Arun District Council
Planning Department
Council Offices
Maltravers Road
Littlehampton
West Sussex
BN17 5LF
SENT VIA EMAIL ONLY

Planning application reference: LU/91/19/PL

Change of use of parts of seafront for temporary food & drink outlets & other seaside uses together with associated temporary/portable structures & equipment for use by businesses associated with those outlets.

Various sites along Littlehampton Promenade, Littlehampton

SITE LOCATION PLAN AND
BLOCK PLAN - SITE C&D

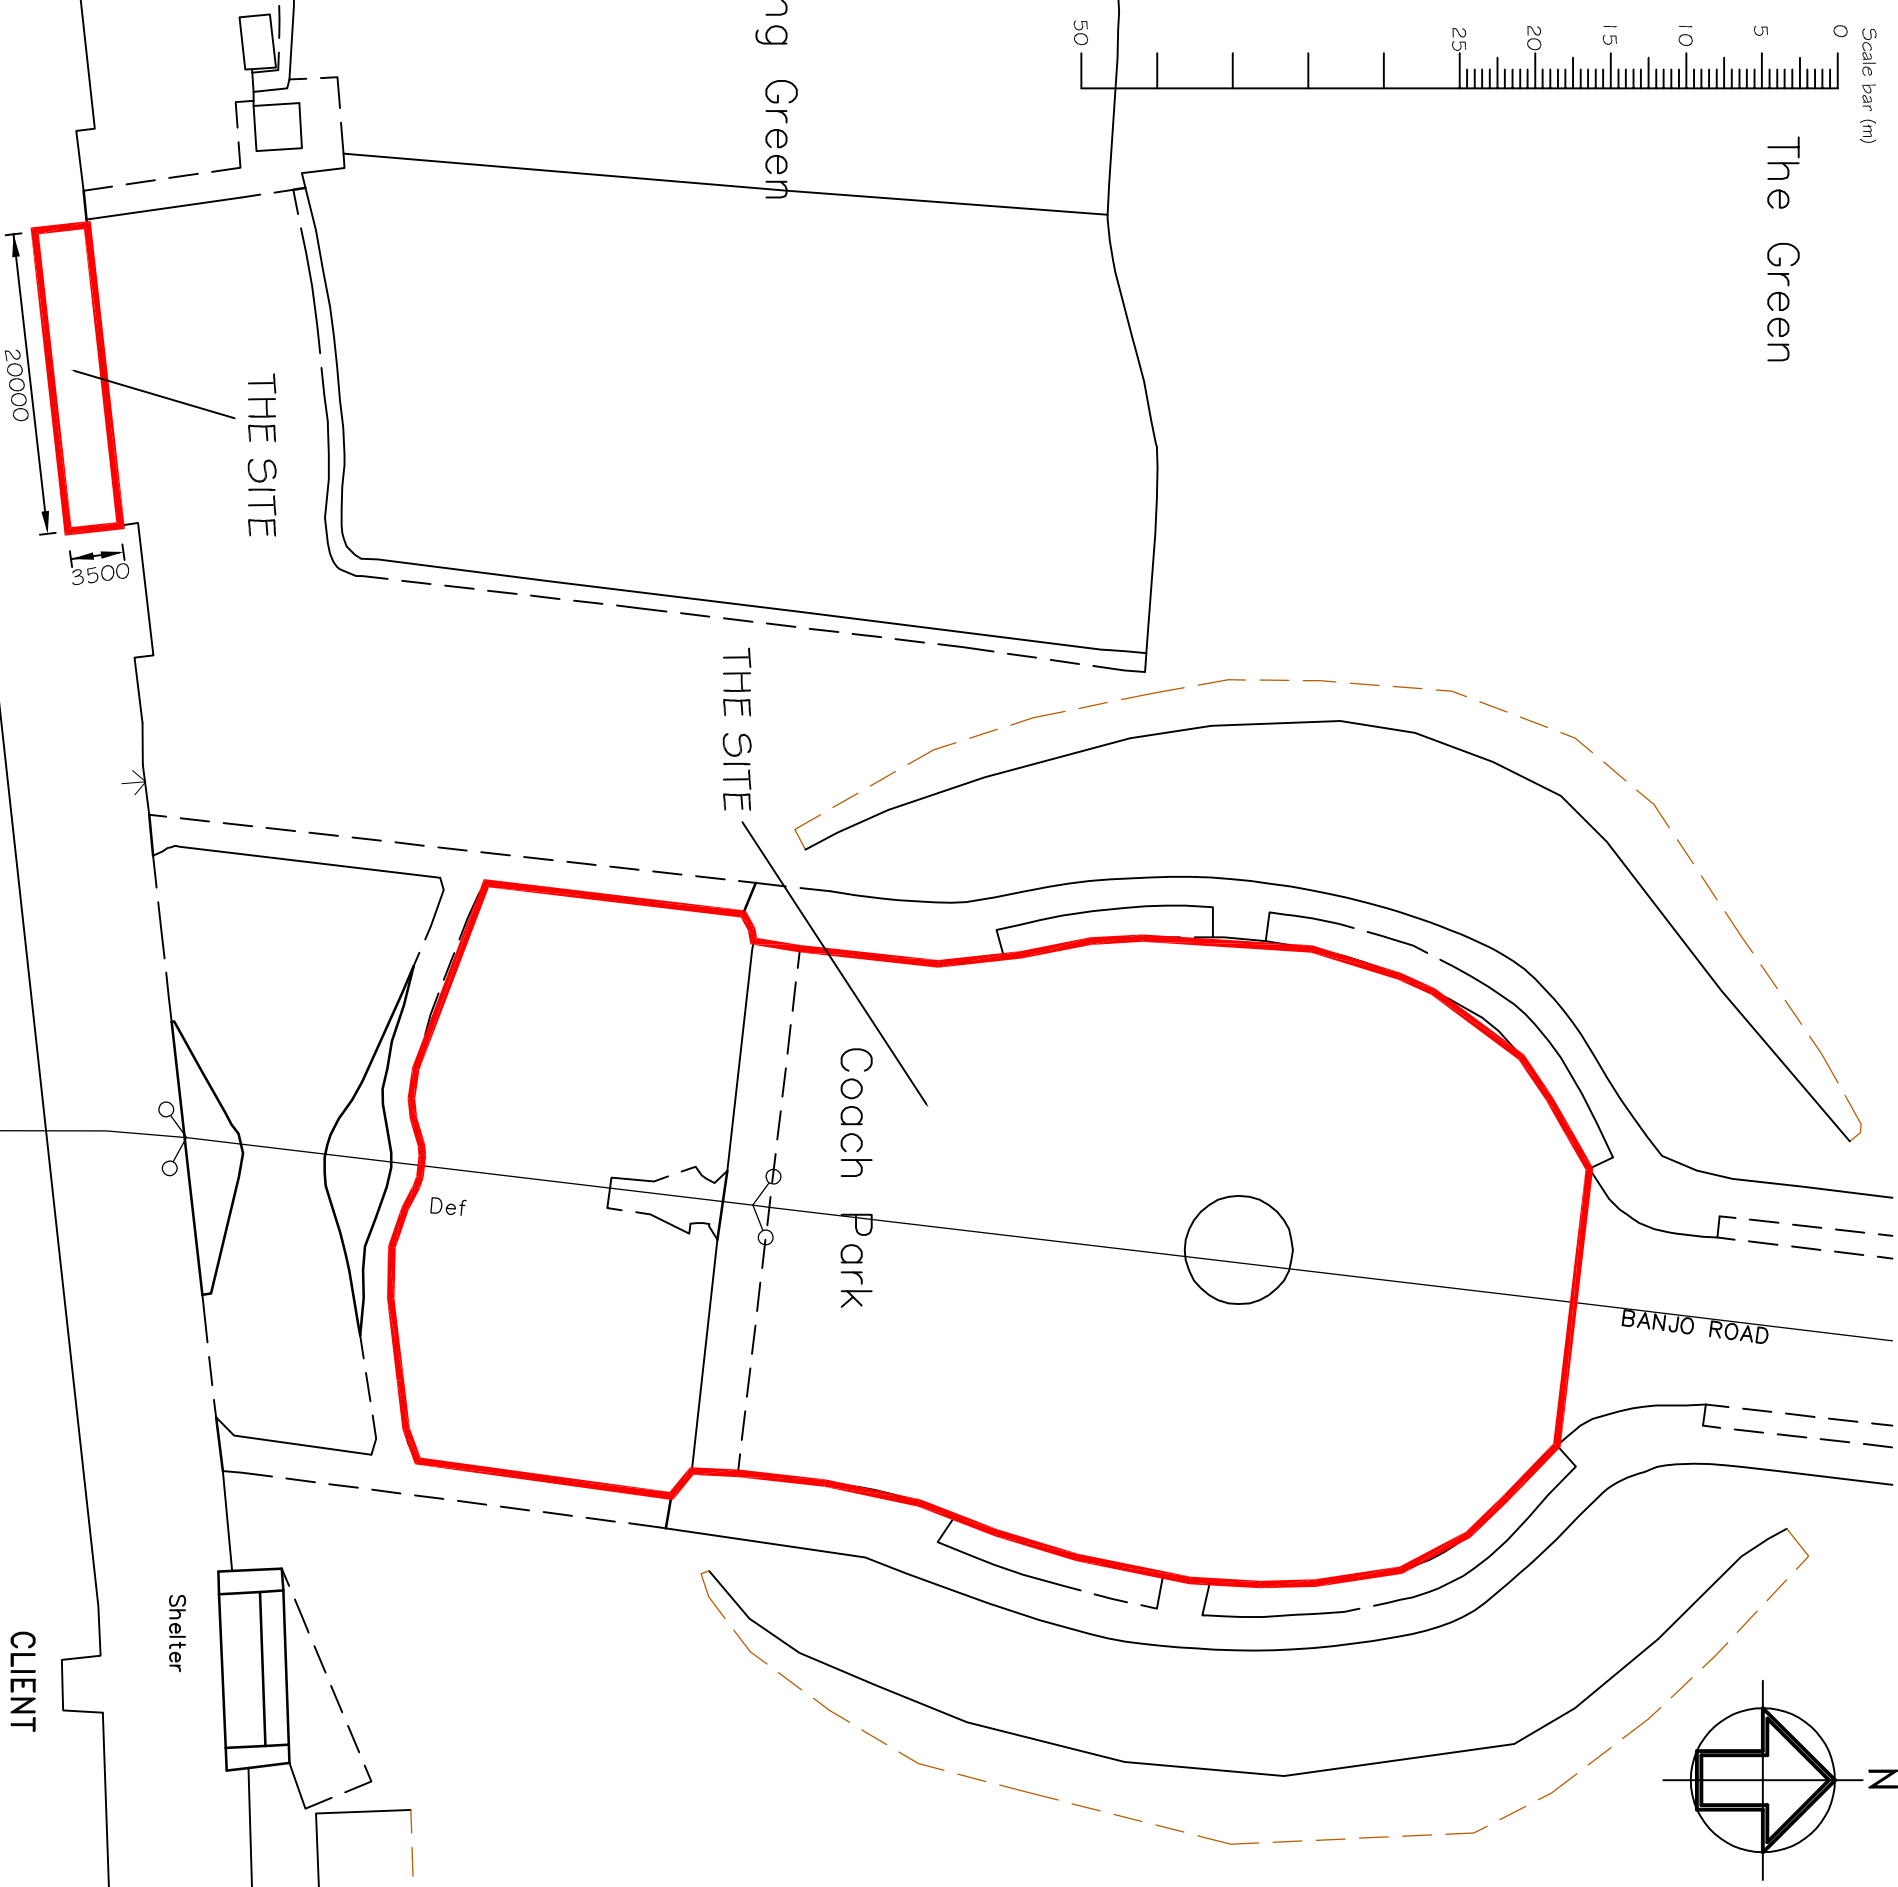
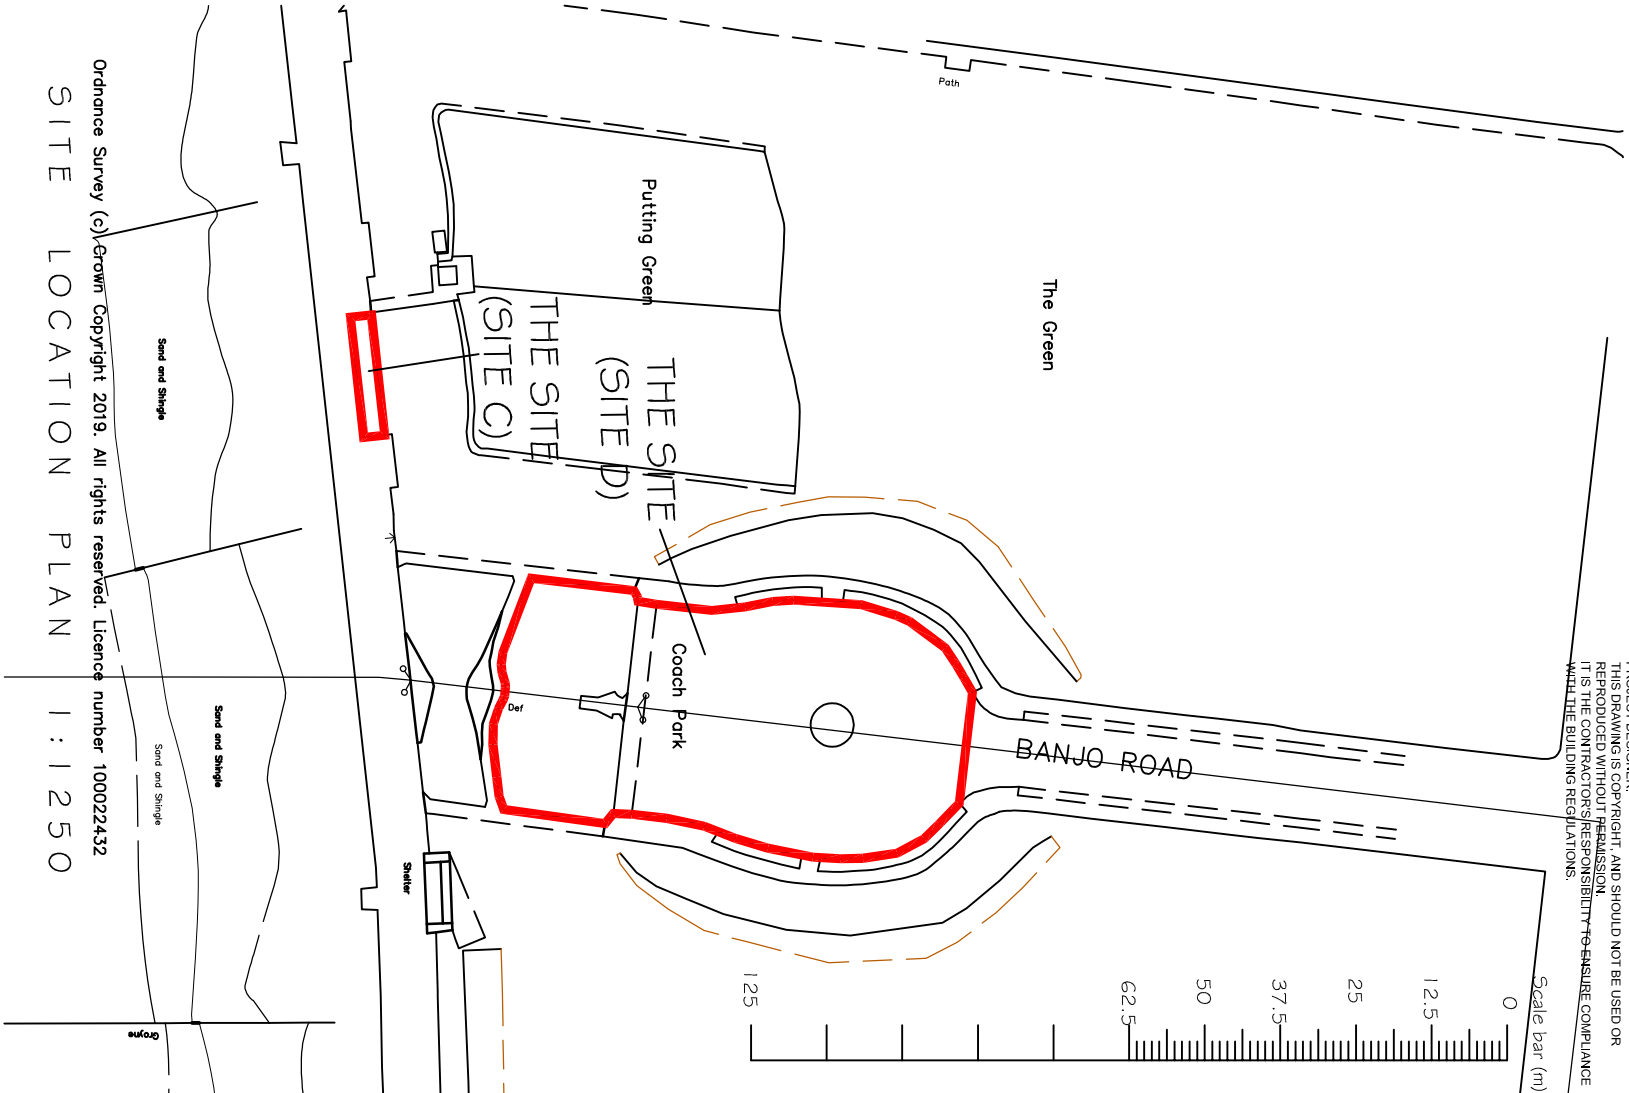
- 3.13 According to the submitted details, both sites incorporate an area of the existing promenade measuring 20 metres long by 3.5 metres deep. This will create a significant narrowing of the existing width of the promenade, and we are concerned how this will impinge on this well used thoroughfare, which is integral to Littlehampton's charm and tourist offer. The promenade is used by pedestrians, cyclists, the motorised prom train, and servicing vehicles. If development is approved at Sites C and E, this activity will continue, but in very close proximity to the (presumably) new kiosks. In busy periods, queues of people will spread onto the non-demarcated promenade creating a further narrowing of the public thoroughfare and significantly impinging on access.

- 3.23 Finally Policy D DM1 requires that in terms of scale the proposals should be in keeping with the local context. We consider that the application would clearly fail in this respect. The 20 x 3.5 metre size of the kiosks proposed for Sites C and E could also lead to a density/mass of

- 3.24 This site is the existing coach park, which is well used in busy periods. It is an open area, which is surrounded by designated open space. To fill this area for an unspecified period with kiosks or other outlets would lead to the degradation of the areas defining visual qualities.

- 3.25 Arguably of even greater importance is that if the entirety of the area proposed is used for commercial purposes, then what will be done to accommodate the displaced coaches that currently utilise this area? This is an important local facility, which coach operators are attracted to due to its ease of use, size and proximity to the beach and nearby attractions – which is a commodity in such a coastal location. These coaches bring many much-needed tourists to the area, who support the existing businesses.

THE SITE
(SITE B)

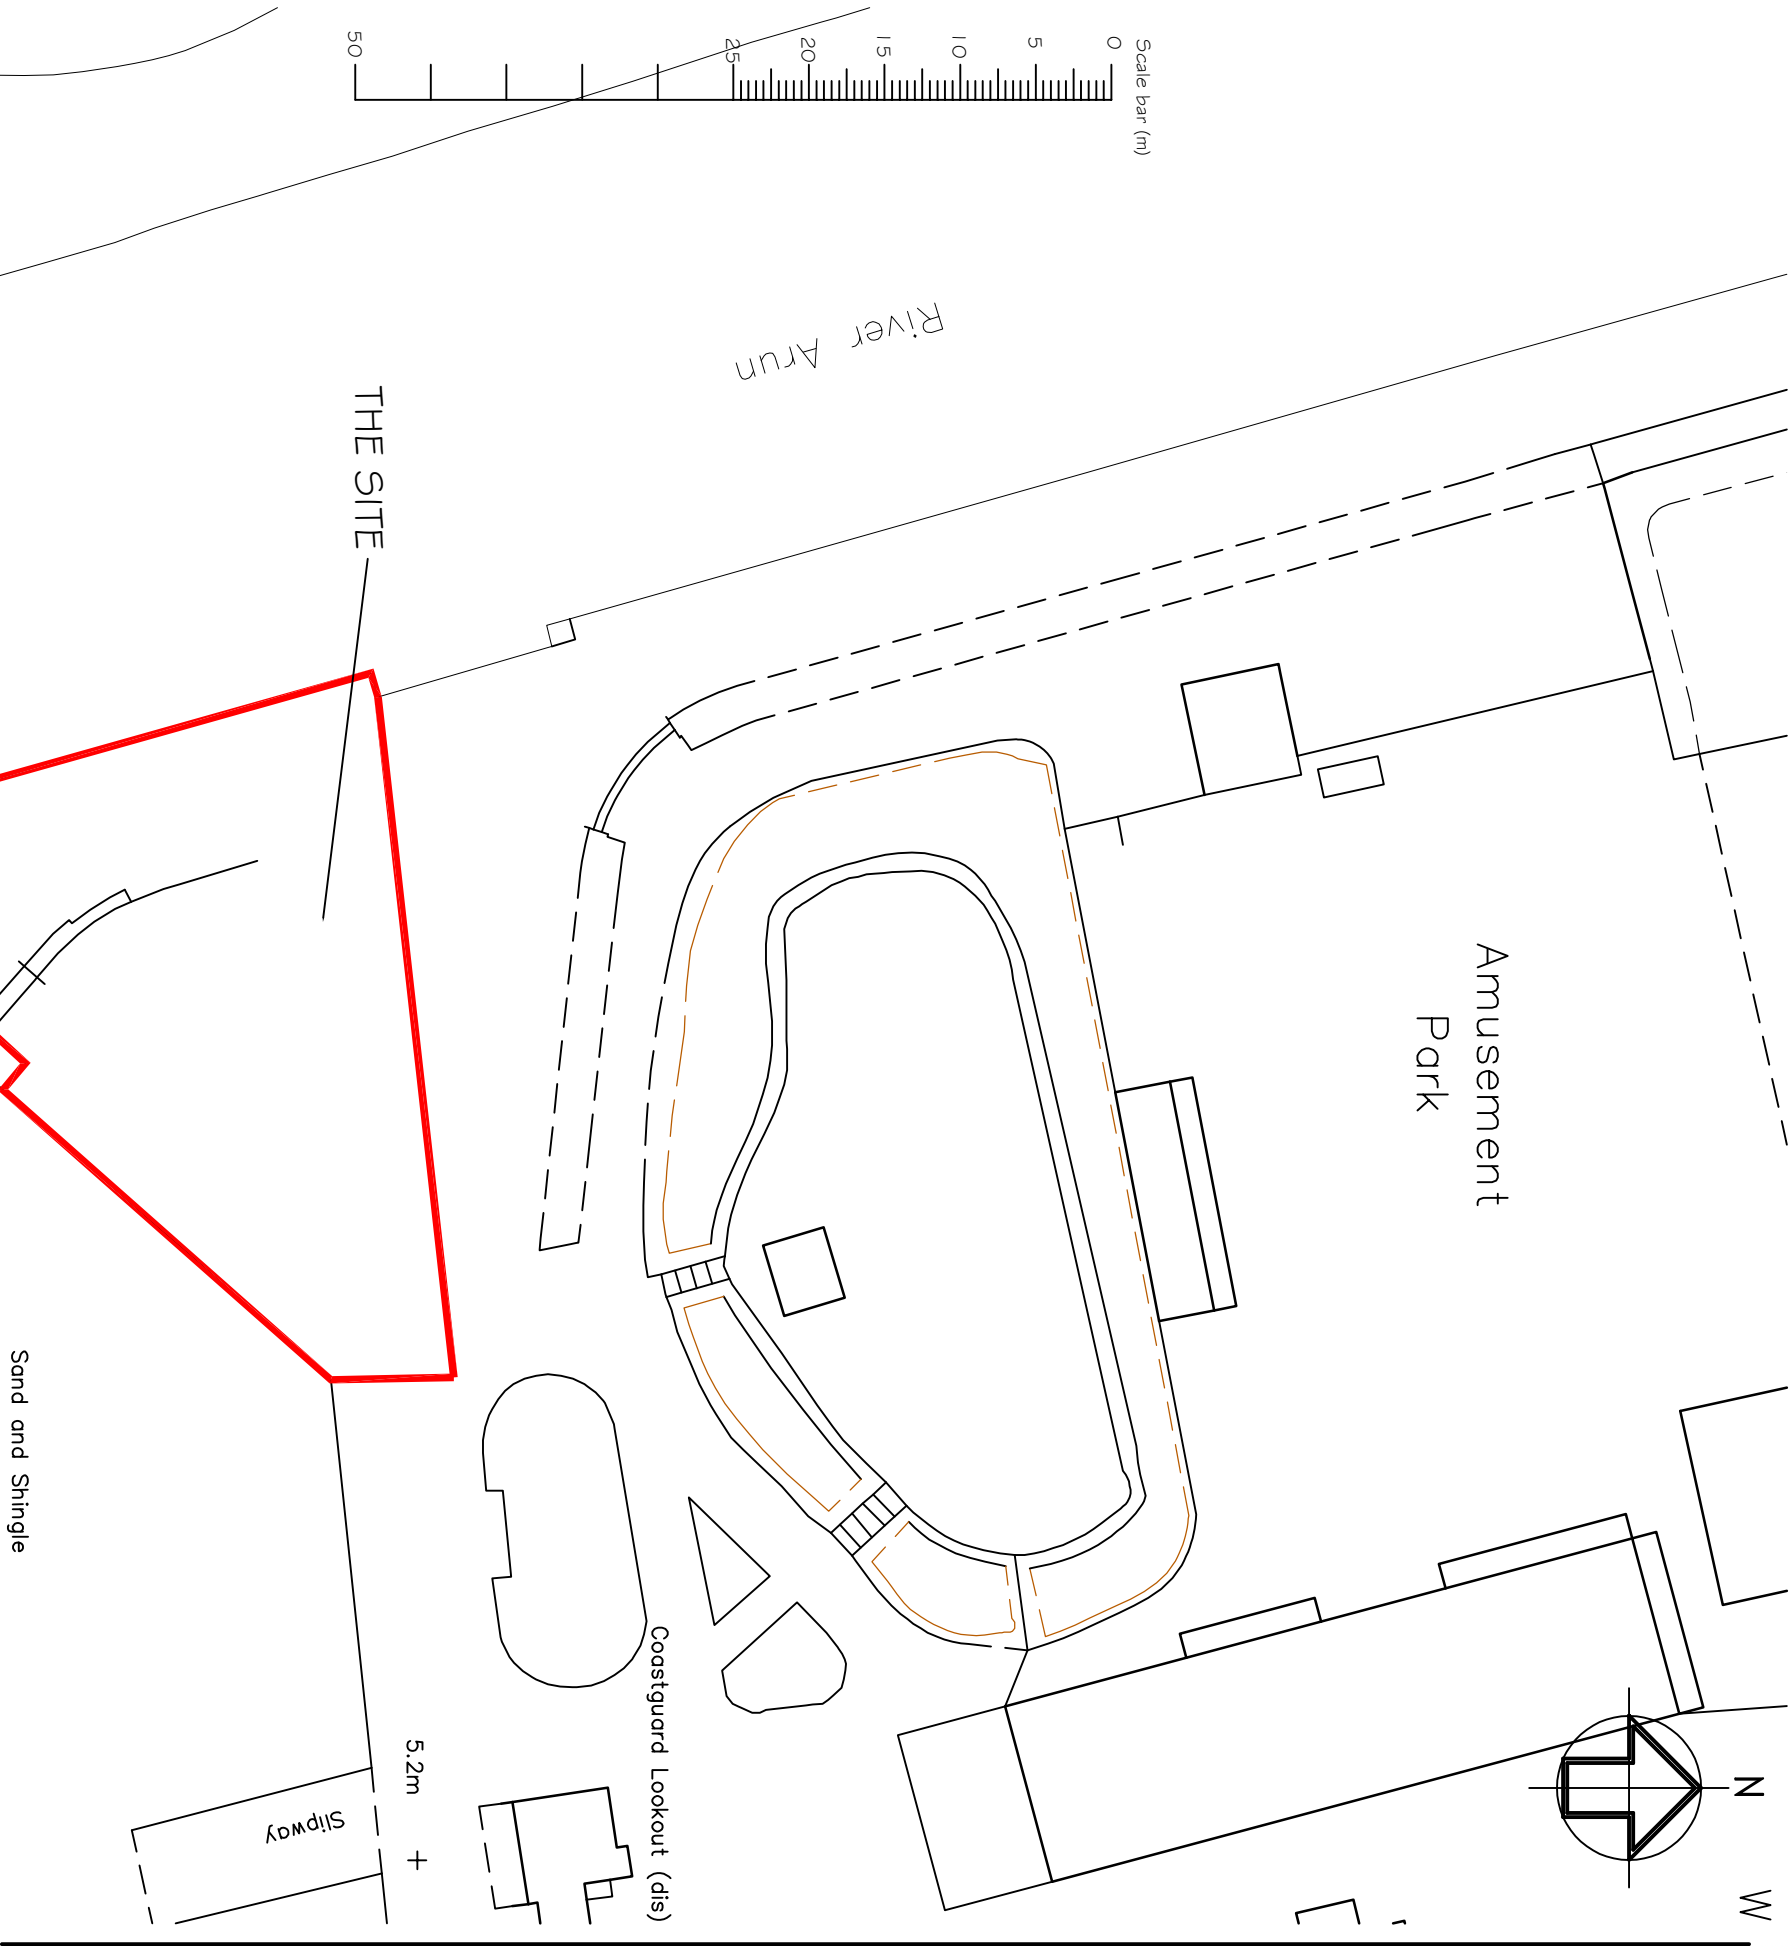
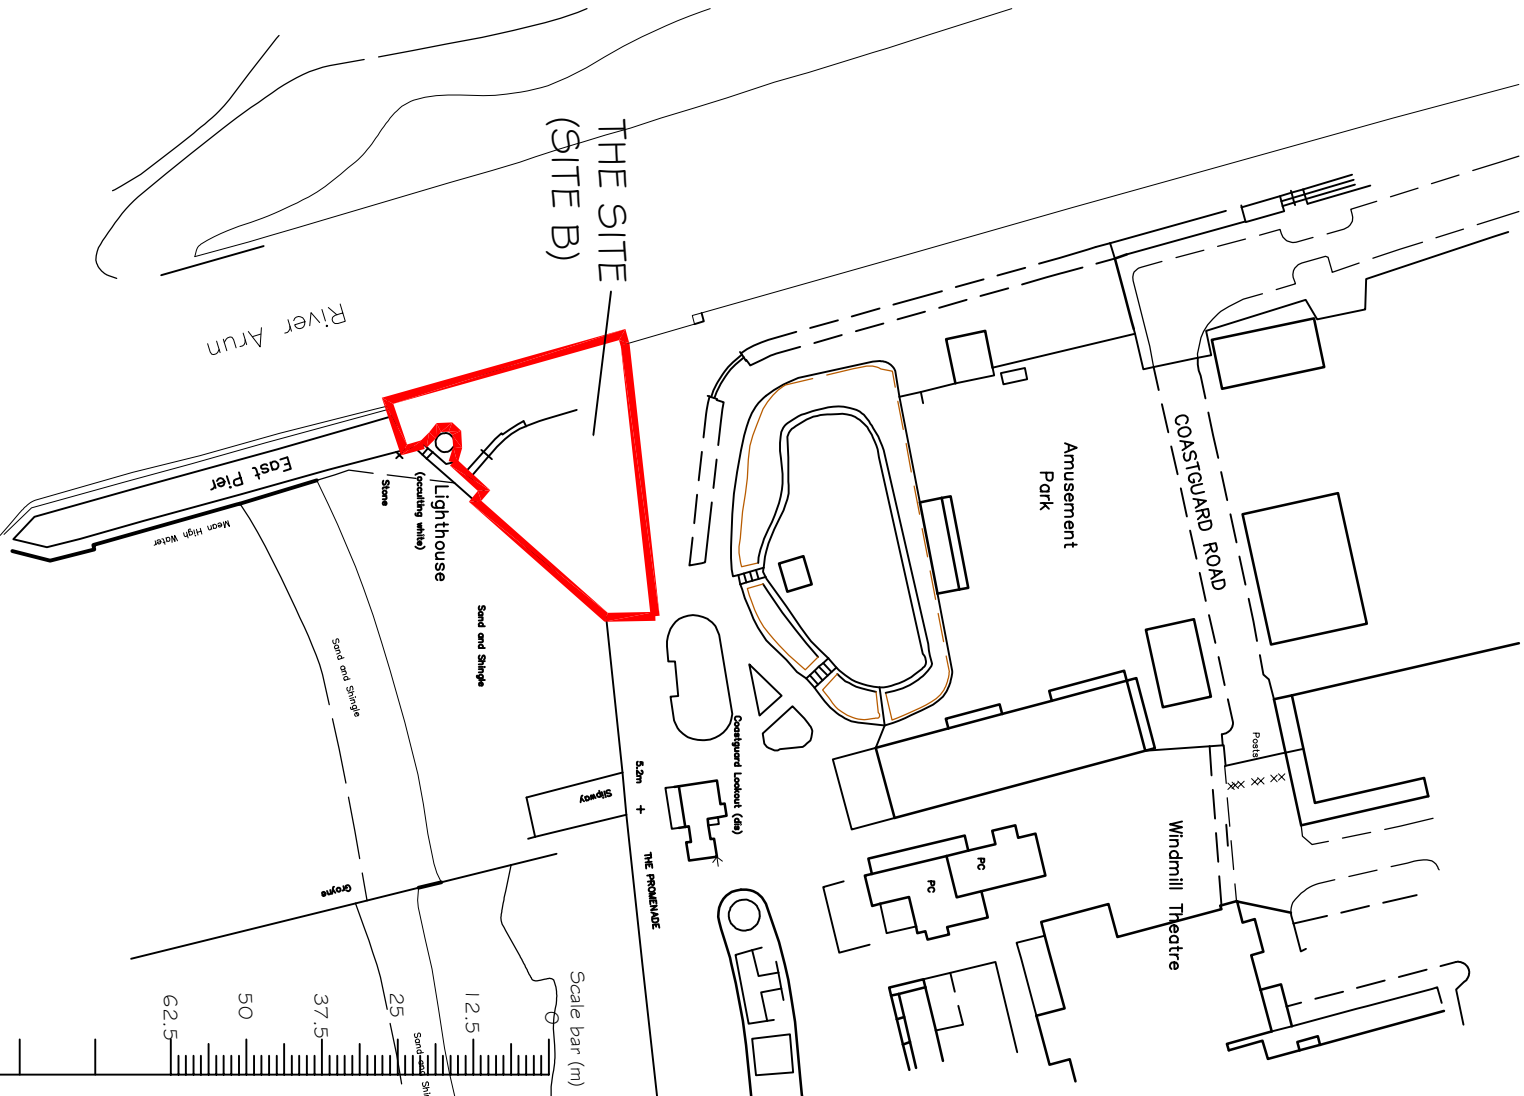
- 3.10 In respect of Site B we also query why such a large area has been identified. This alludes to a more extensive use than that broadly indicated by the application description. Again, further clarity is required in order to provide comfort in this respect. Ideally, a more defined red line area should be submitted.
- 3.11 Essentially, without more detailed information relating to the proposed and extent of the use at Site B, then our stance is that we object to this element of the planning application, primarily due to potential impact on the open character of the locality.
